**Please add the following: 3rd review**

**Unresolved Review 1 Comment:**

LOT BOUNDARY

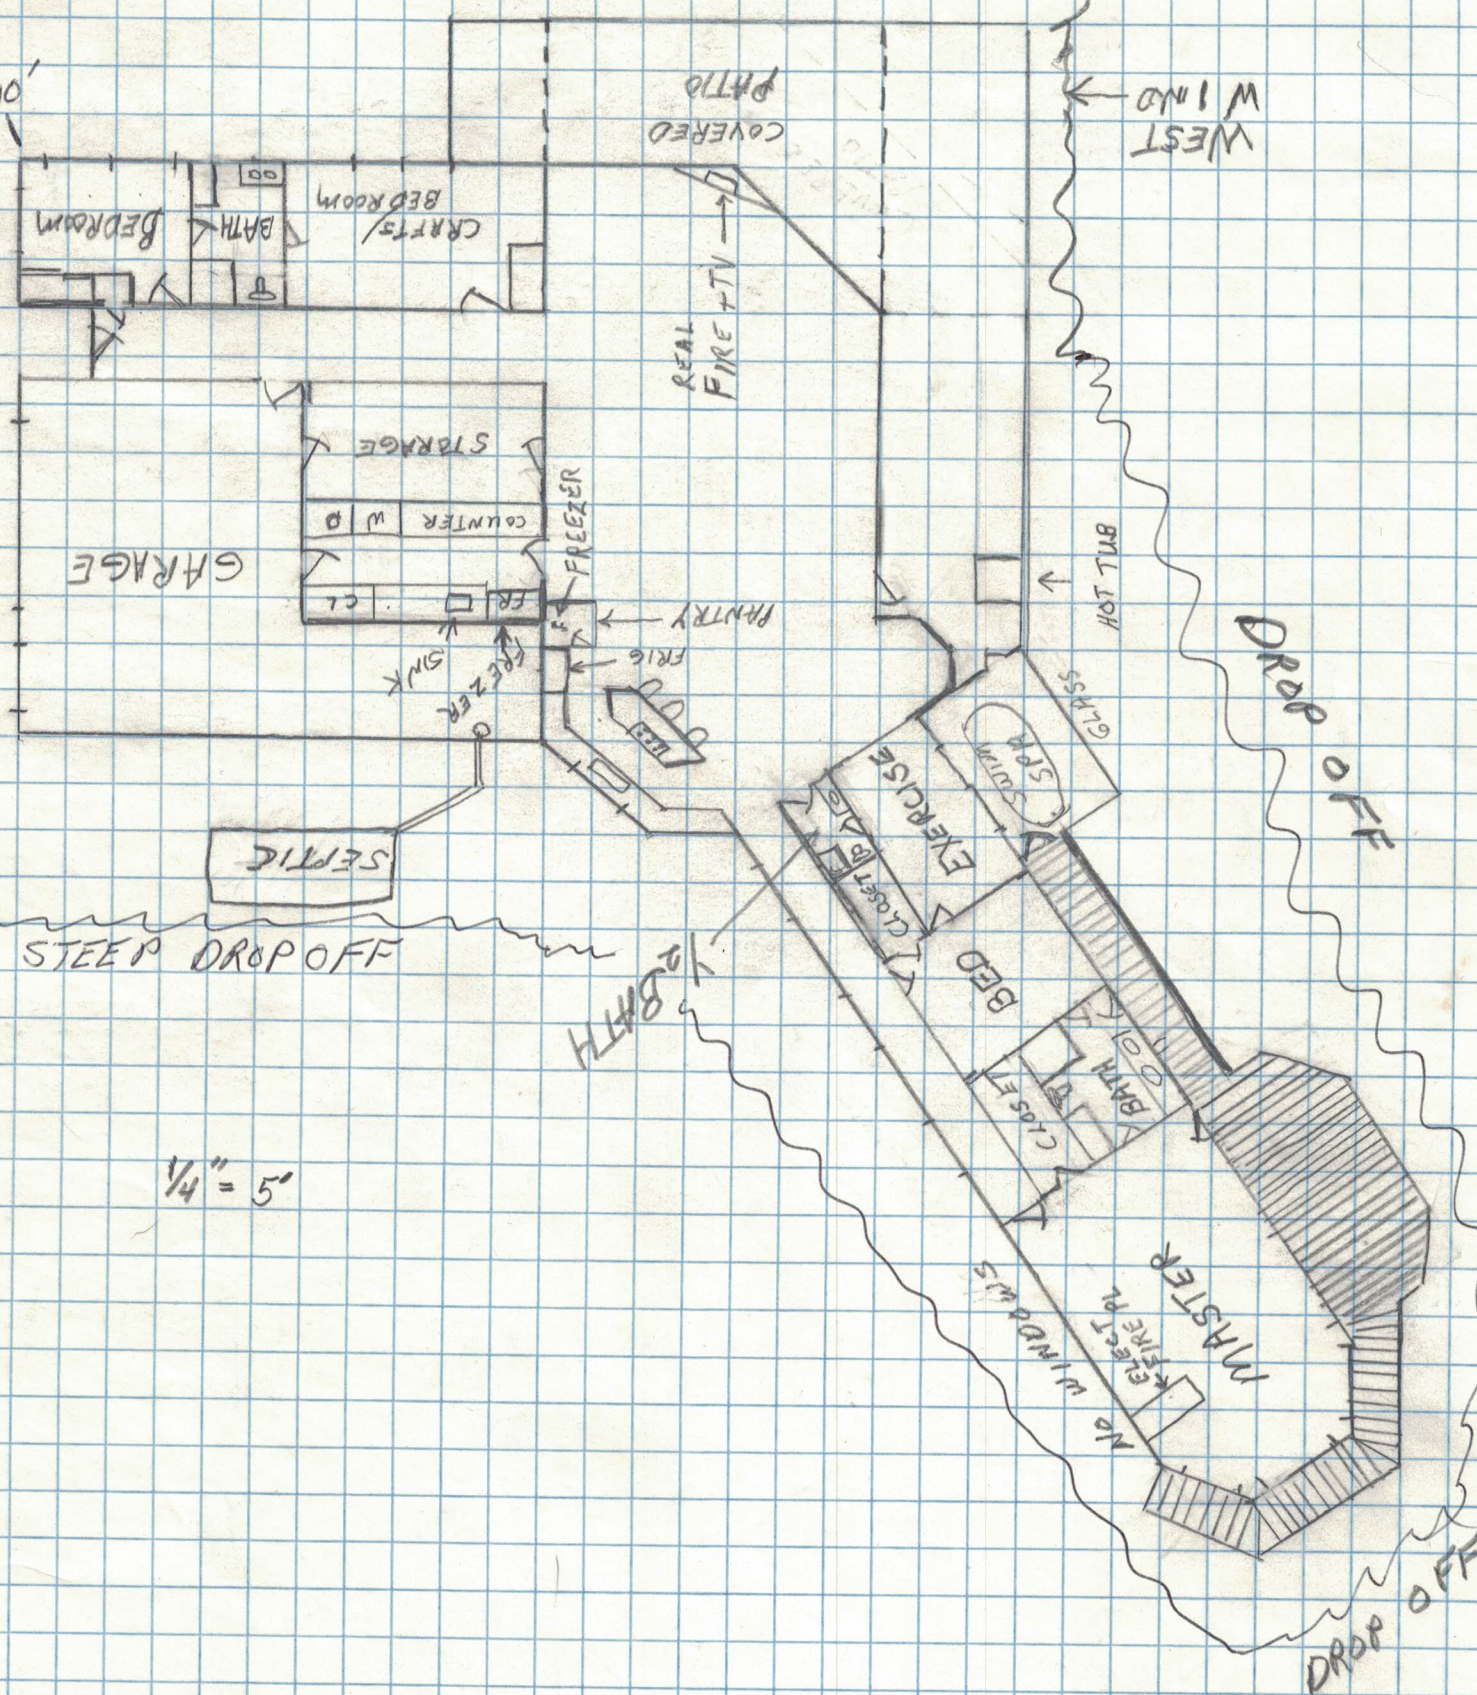
- Please contact Engineering to discuss before resubmitting. They want you to utilize the site plan from the second submittal and just update it as requested. Please include the items listed below from the 2nd review on this drawing:

- Owner name, contact telephone number and email
- Applicant name, contact number and email
- Property address
- Property tax schedule number
- Legal description
- Lot size
- Lot area coverage calculation
- Current zoning of property
- Add the square footage of the proposed home
- Add setback distances from the proposed home and all property lines
- Include any driveways
- Location of all existing and proposed utility lines

- Please show all easements on the property. Per title commitment submitted by applicant there is a utility easement alongside Northfield Road. Please see document for reference.
